Phone: 0300 123 6780
Email: Kathryn.Walsh@lancashire.gov.uk
Your ref: 3/2025/0171
Our ref: 3/2025/0171/HDC/KW
Date: 03 April 2025

Location: Lower Fold Stables Northcote Road Langho BB6 8BE
Proposal: Change of use of building and associated land from Stables and Dog Groomers (Sui Generis) to an Animal Physiotherapy Centre (Sui Generis).
Grid Ref: 370347 435751

Lancashire County Council acting as the Local Highway Authority does not consider that the application, as submitted, fully assesses the highway impact of the proposed development and further information is required as set out in this response.

**PROPOSED ANIMAL PHYSIOTHERAPY CENTRE
BUILDING PLAN**
SCALE - 1:100

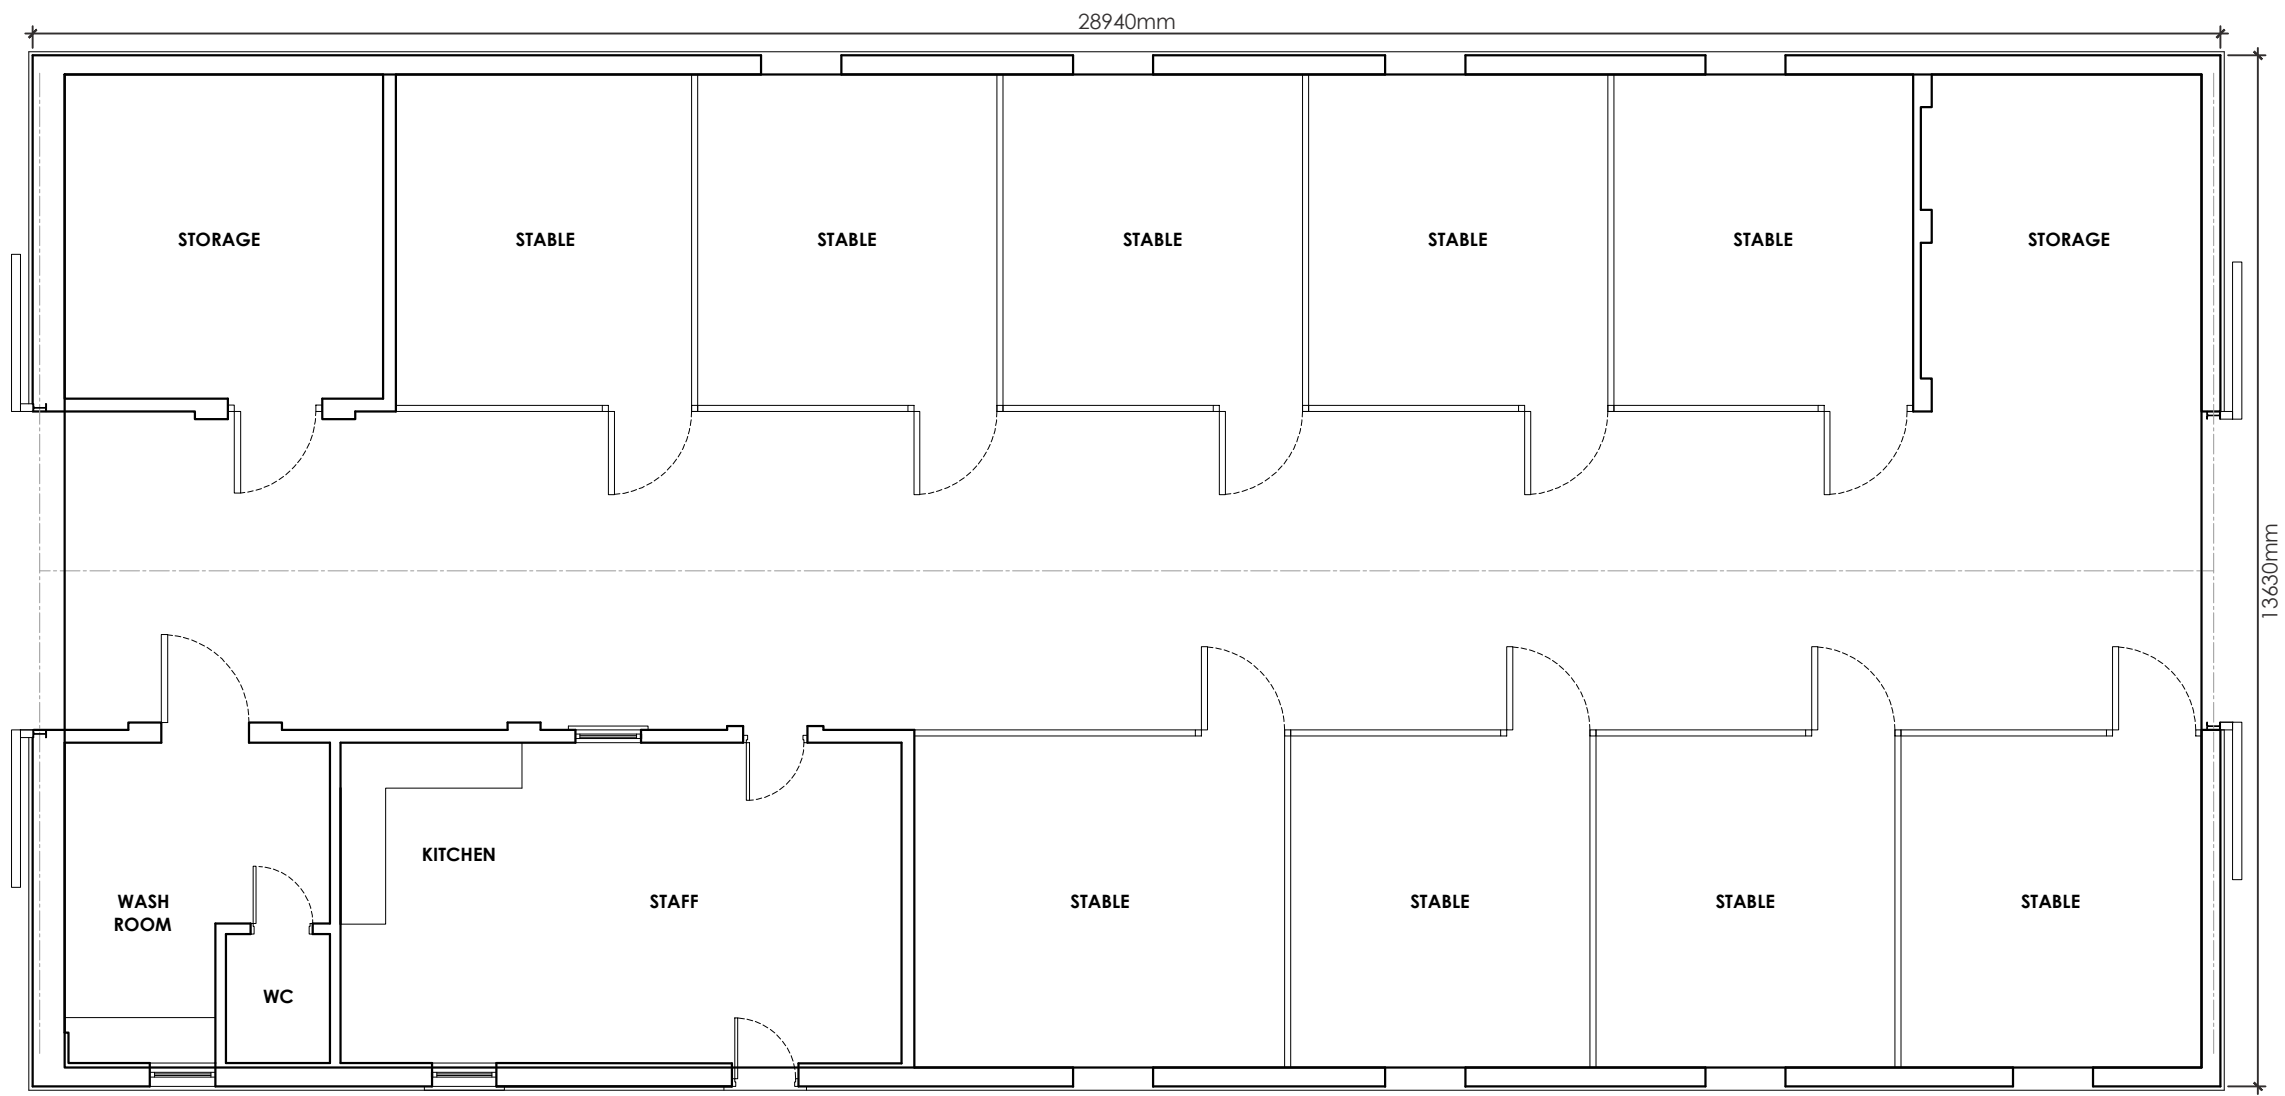
In the Operation Statement, along with the expected number of trips the proposal is likely to generate. The proposed plan shows 9 stables will be retained as part of the development, the applicant should detail if the facilities of the site will only be used for the horses staying in one of the 9 stables on site or will it be used for further commercial purposes or for horses which are not boarded at the site? Should this be the case, the use of the facilities shall be by appointment only and if so, how many appointments are expected per day?
